From: [REDACTED]
Sent: 21 June 2016 16:13
To: DevelopmentControl & DevelopmentManagement
Subject: 132 park grove. multi occupancy house

LAYOUT AS PROPOSED

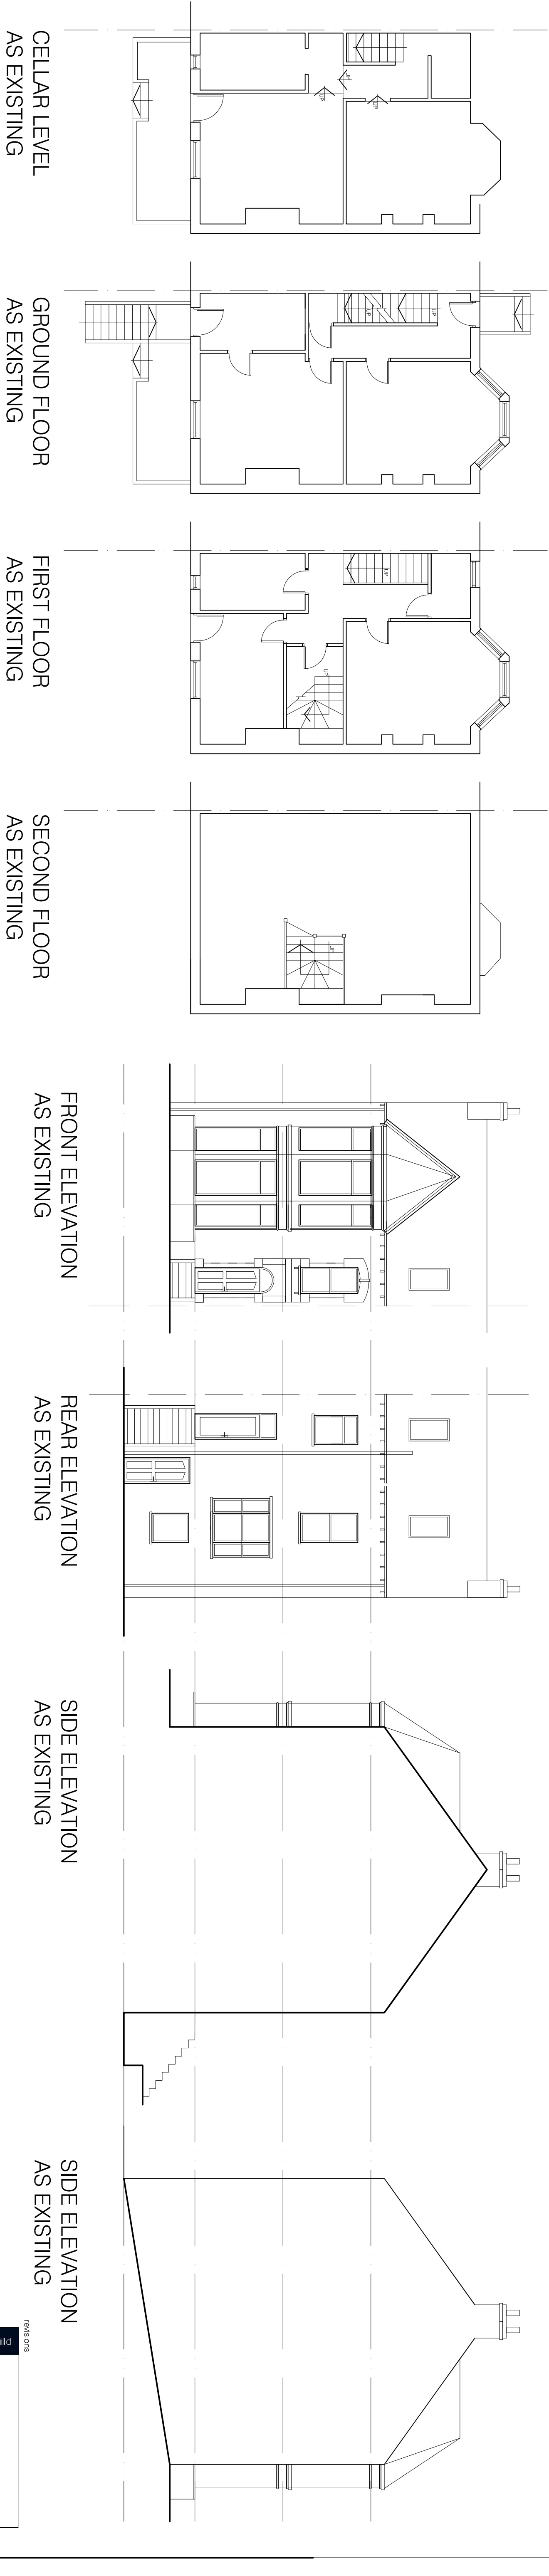
On planning for 132, this is pretty much the same as 118. The plans show that the ground floor lounge is to be converted into a bedroom so the house as planned will be 5 bedrooms with a shared kitchen, no family lounge and obviously not a family home. Add the cellar flat that has 2 bedrooms then the existing family home becomes a 7 bedroom multi rental.
